**From:** Joey Davis <joey@dclugston.com>  
**Sent:** Thursday, November 17, 2022 9:55 AM  
**To:** Cynthia Pierce  
**Subject:** RE: Wood Grove

Thank you for taking the time to review and email me about Woodgrove.

2 Enlarged Restroom Plan
1/2" = 1'-0"

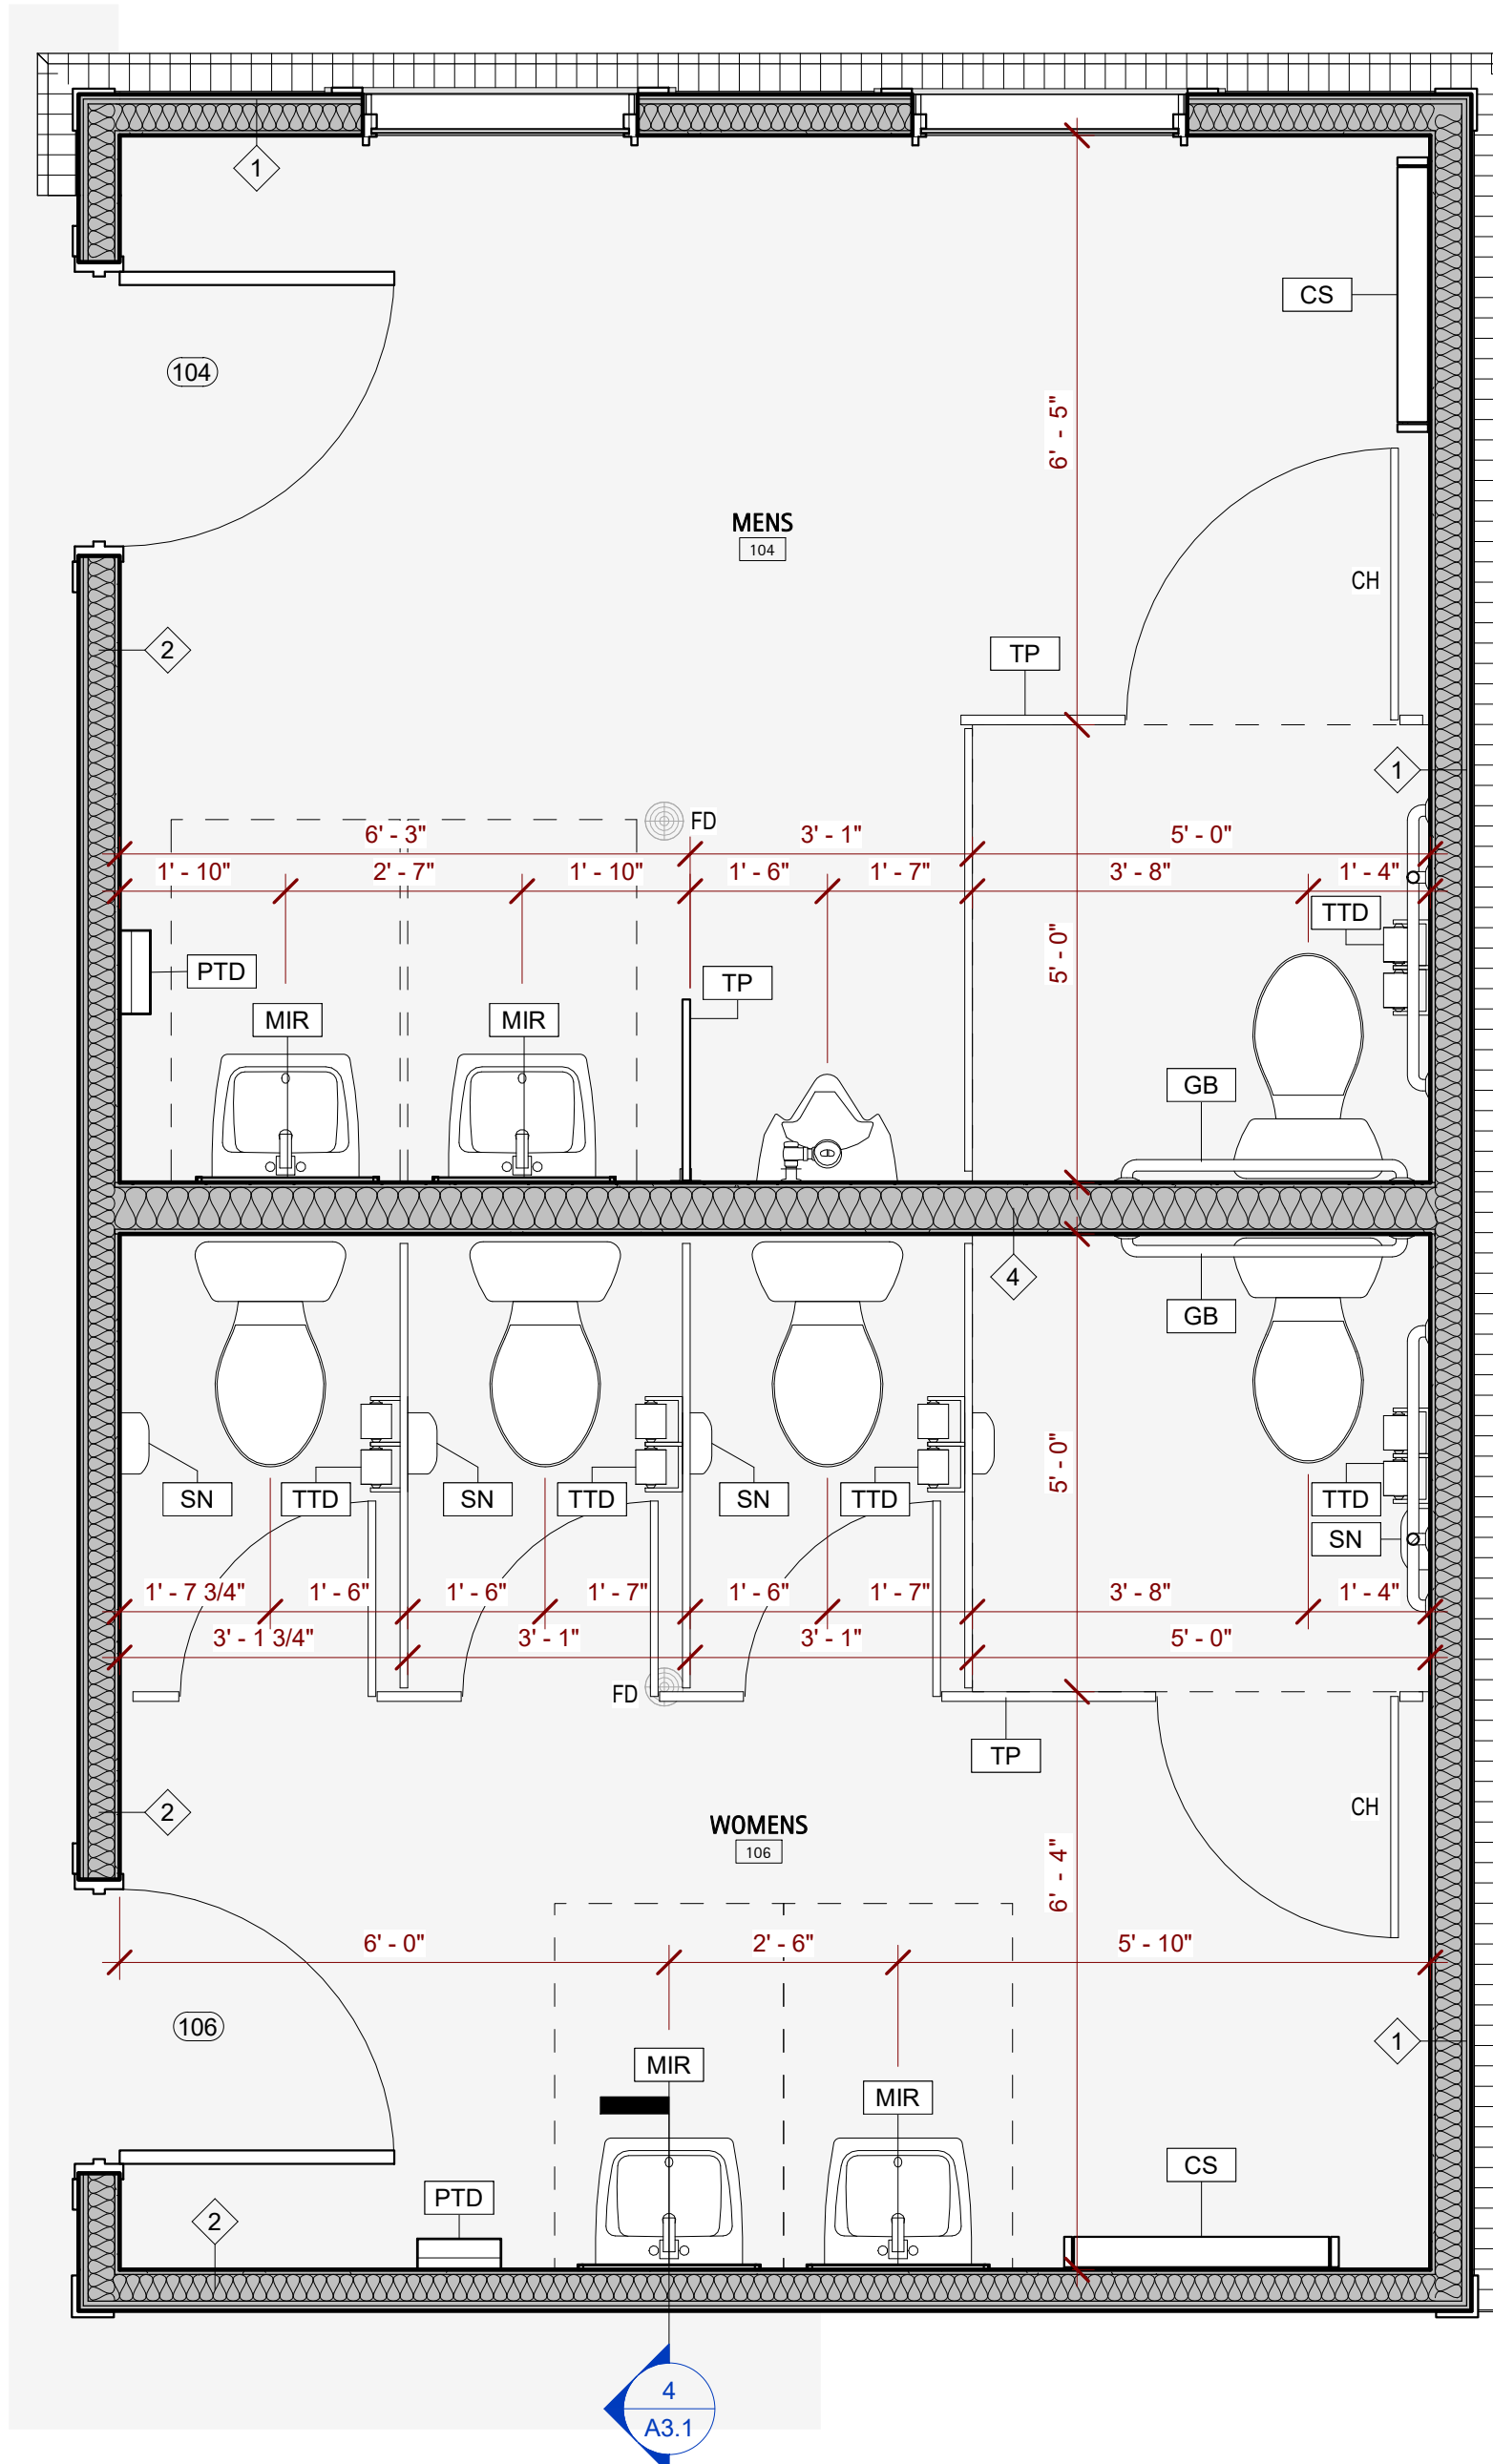
3. No soap dispensers are shown on the lavatory areas on the enlarged restroom plan.
  - a. There will be soap dispensers installed once the building is complete. This is a design choice by our owner to not show these on the plans because he is requiring the HOA to provide these for installation.

WATER SUPPLY PLAN: SCALE - 1/4" = 1'0" | 2

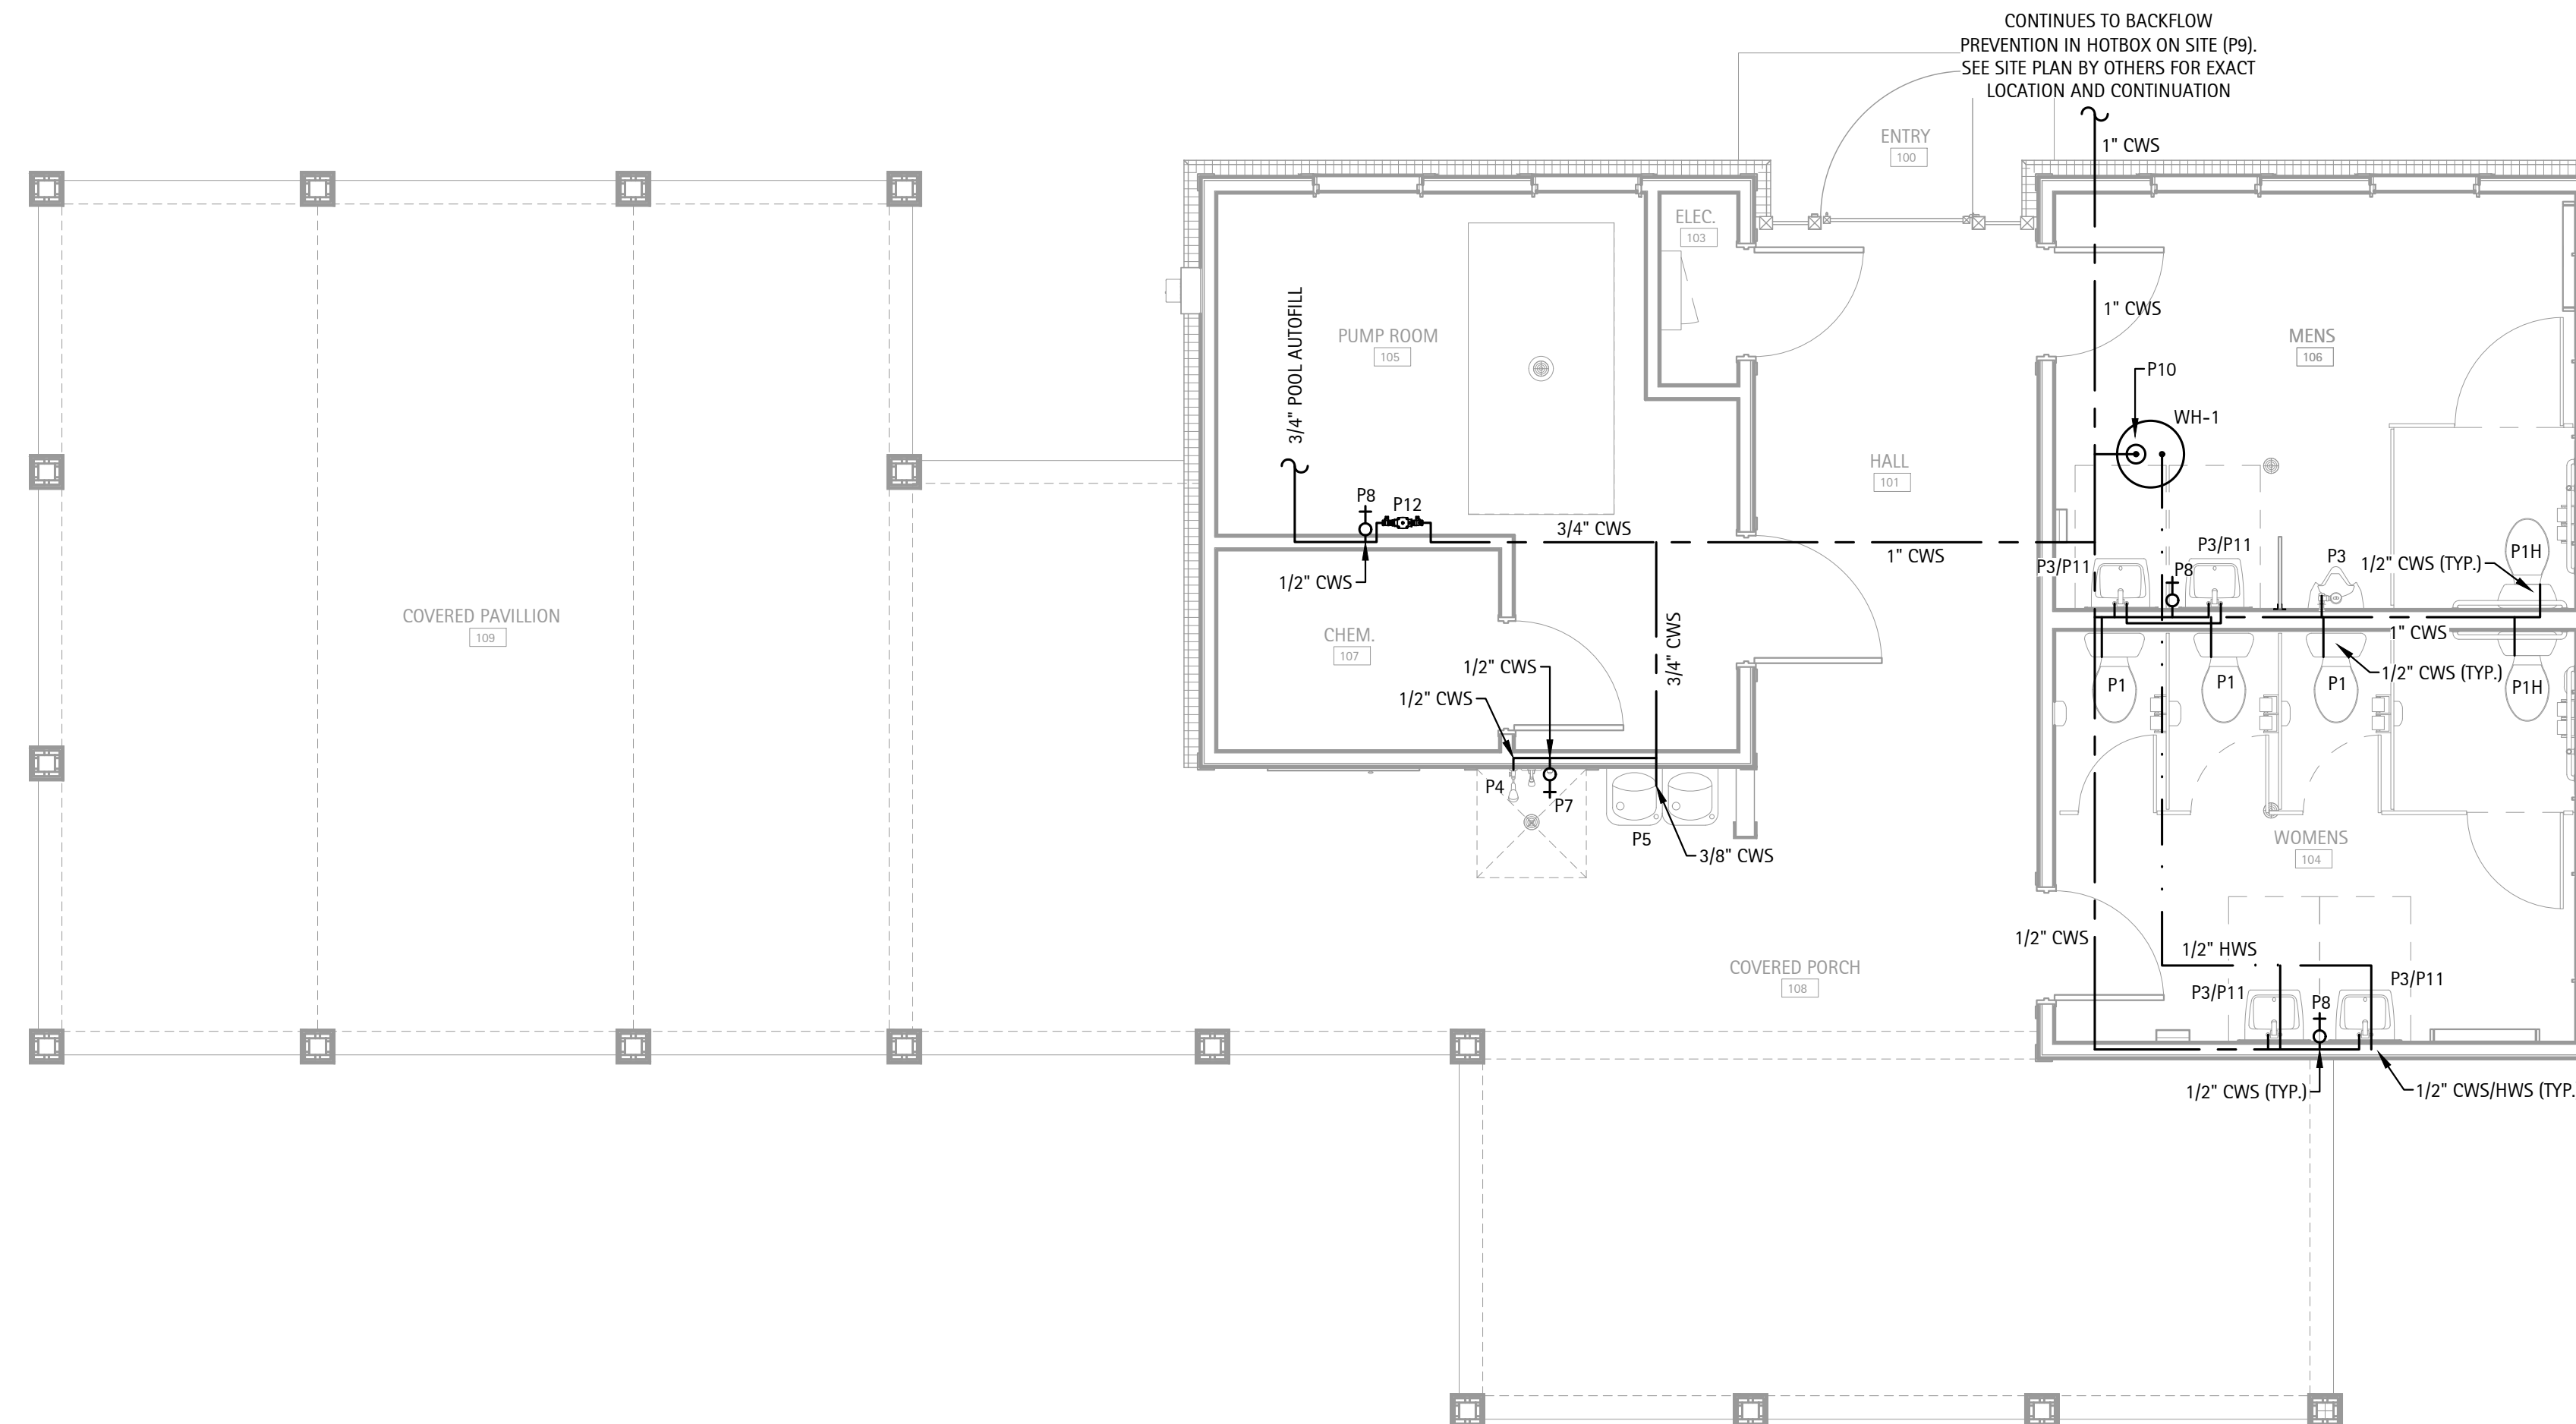
4. The autofill line is reflected on P2 water supply but is not included on the SP4 enlarged pump room plans.
  - a. The autofill line will come directly from the RPZ in the pump room and run underground to the pool. Depending on the project, I don't typically show this in the enlarged pump room plan but can include it in the future if you would prefer. I do show the autofill line coming from the pump room to the pool on SP3.2 (Return & Suction Plan).

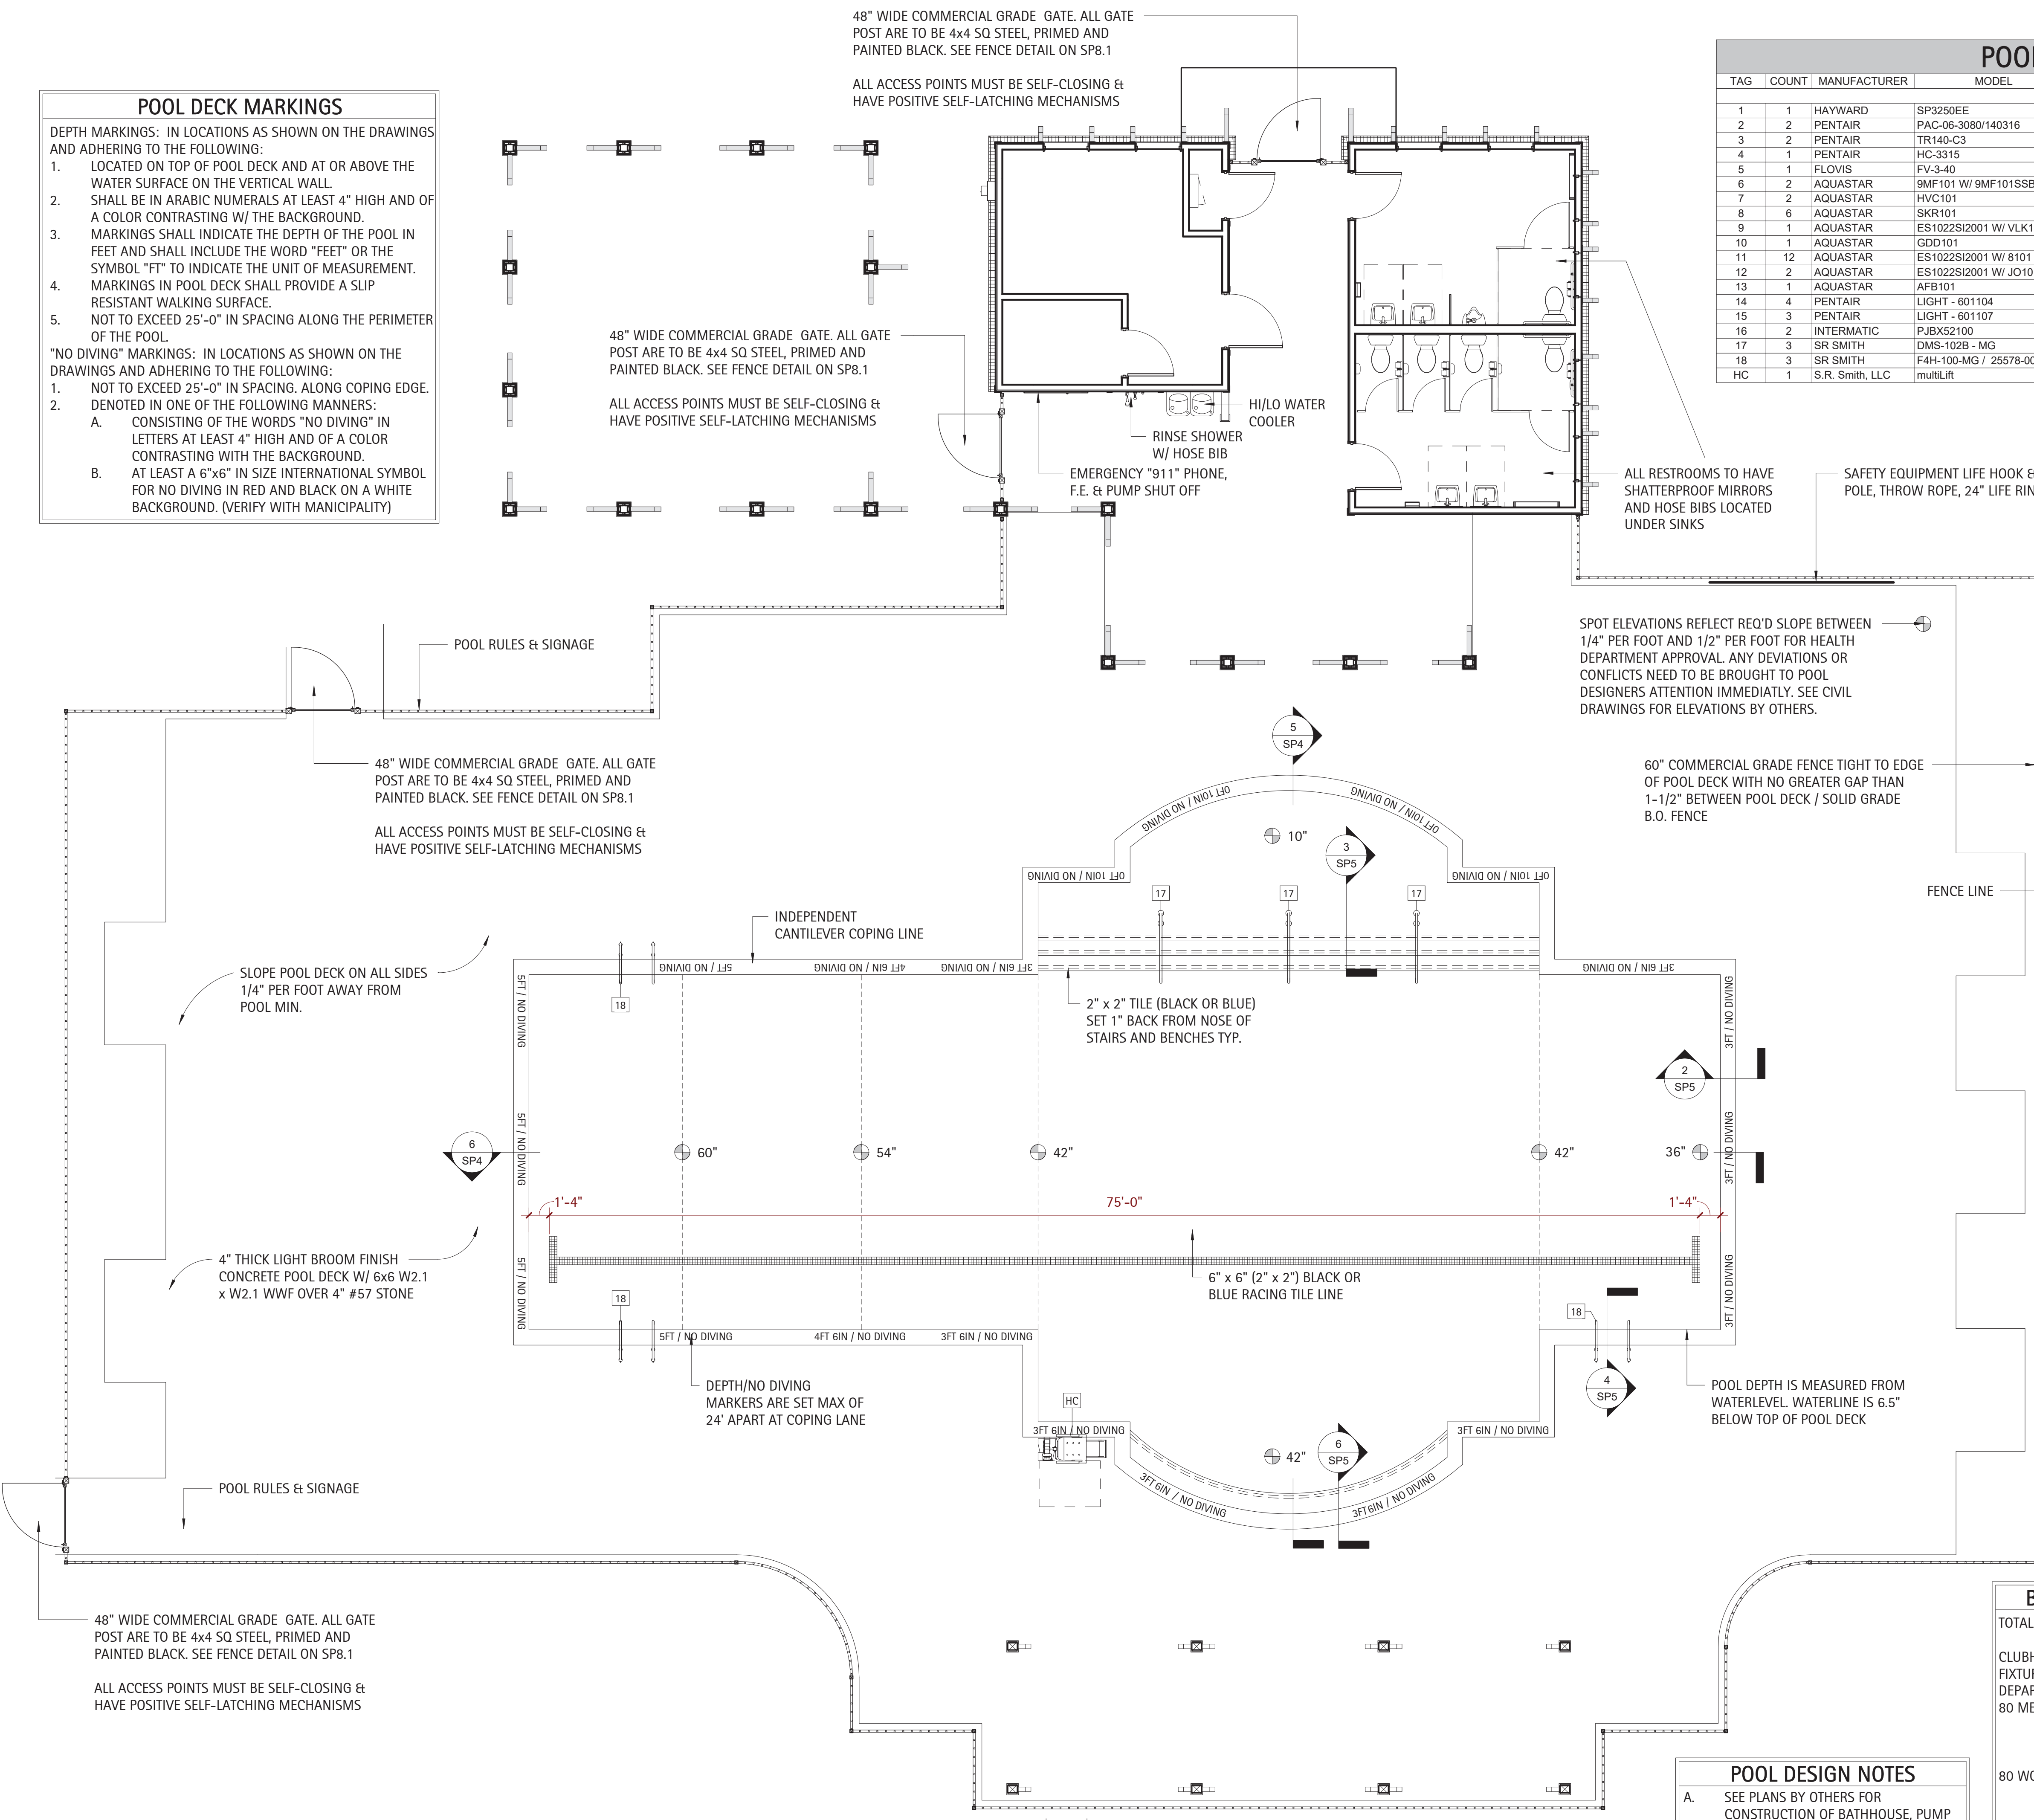
2. The overall length of the pool on the plans is 45' 2" but the data block shows overall length of 42' 2". Can you state which is correct?
  - a. The overall length of the pool is 45' 2". The data sheet shows a typing error on my part. My apologies for that.
